CUMNOR PARISH COUNCIL

BOTLEY WEST SOLAR FARM (BWSF) REF: EN010147

In response to your 11th June 2026 invitation to respond to submissions made to your 28th April 2026 Request For Information, Cumnor Parish Council (CPC) as an Interested Party (IP) is today submitting two documents to you by email:

**Illustrative Masterplan
Figure 5.5F: Cable Corridor Option F**

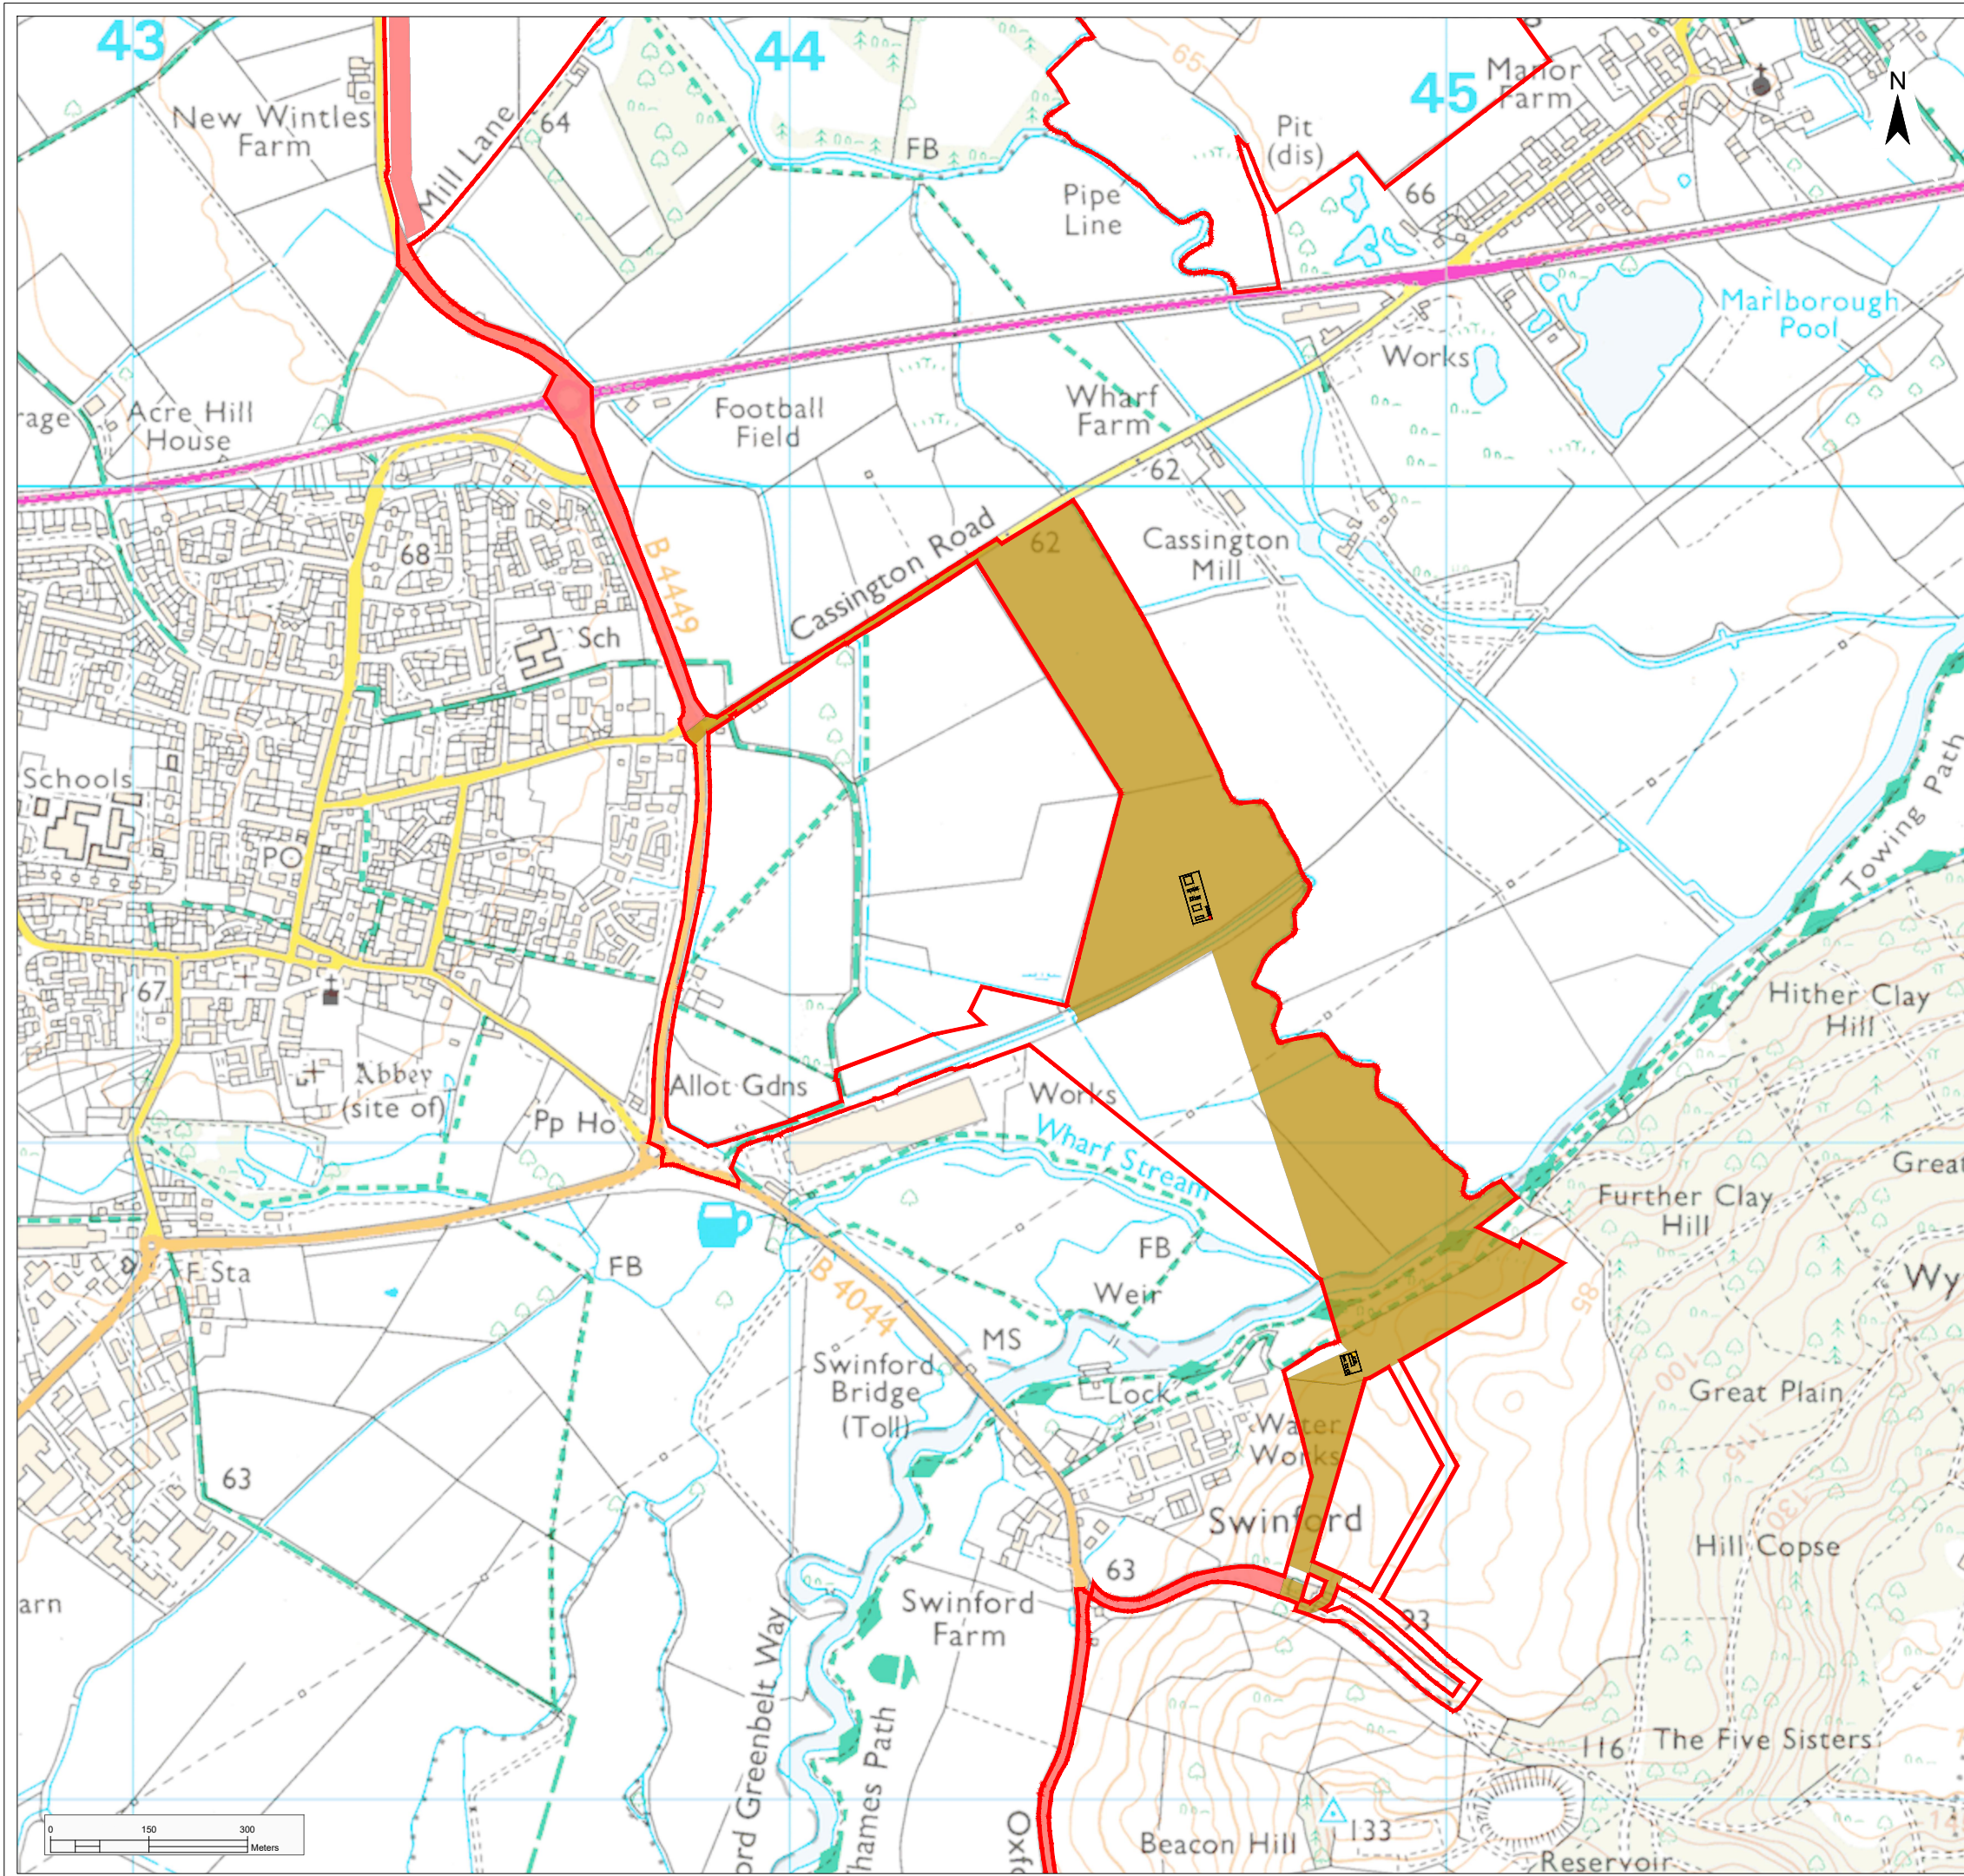
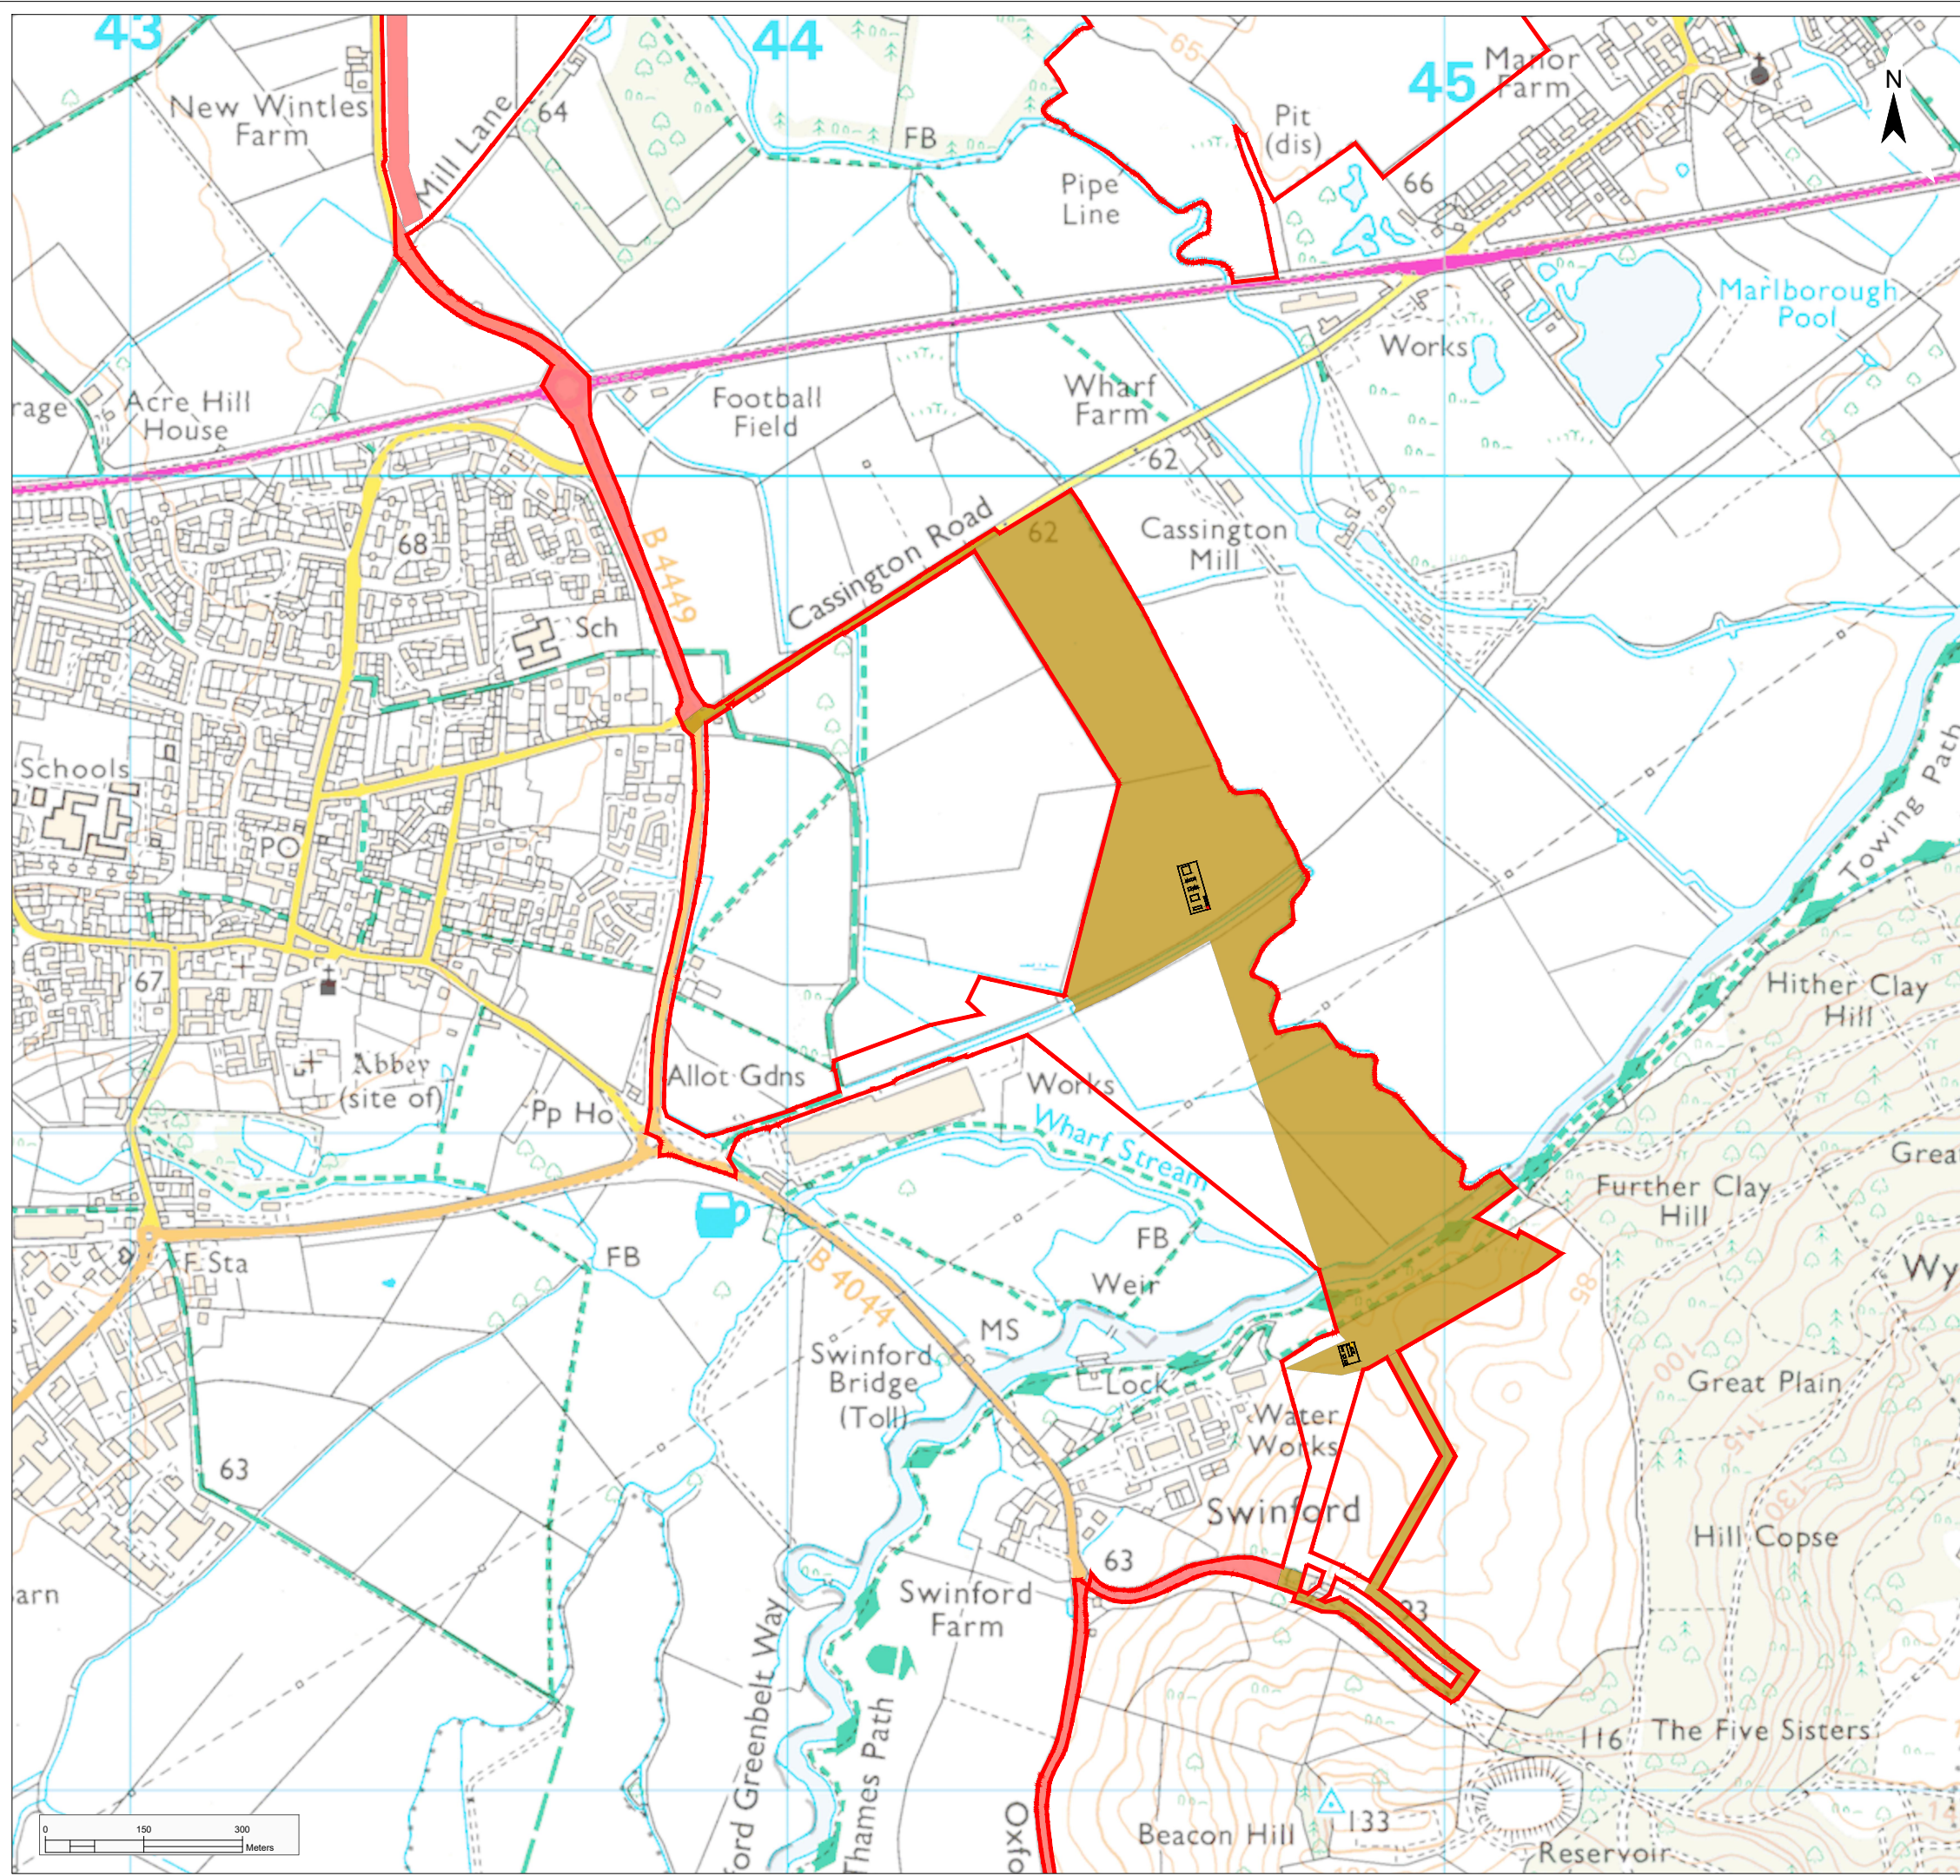
Unfortunately for the Applicant all these impediments are apparently surmountable for their proposed cable connection between the central and southern sites where there are:

- Local Nature Reserves present along the route corridor.
- Ancient woodland blocks (including Wytham woods SSSI)
- River Thames crossing at Swinford: Flood Risk Zones 2 and 3 are present at this crossing - Environment Agency consent required.
- Additional Flood Zone 2 / 3 sections present including the B4044 SW of Swinford (see Map 2 - EA flood risk map - below)

Surprisingly given the Applicant's stated unwillingness to address these impediments for a contrived cable route to Cowley, it is apparently content to cope with them for its central site to southern site cable route.

Except of course it hasn't addressed them in this case either, the prime example being the absence of a '*detailed flood risk assessment*' that satisfies this Interested Party or the OHA for the southern site and the central to southern site cable routing.

Also unexplained is why, if the Applicant is unwilling to bear a cost of c. £10m/km for cabling to Cowley (the Applicant quotes a cost of £150m for 15km to Cowley from the southern site **C1-087 pages 9 and 10**), it is willing to bear that same £10m/km cost, with a total of at least £70m for the c. 7km cable route between the central and southern sites traversing the River Thames near to Swinford Toll bridge in a EA Flood Zone 3 area?
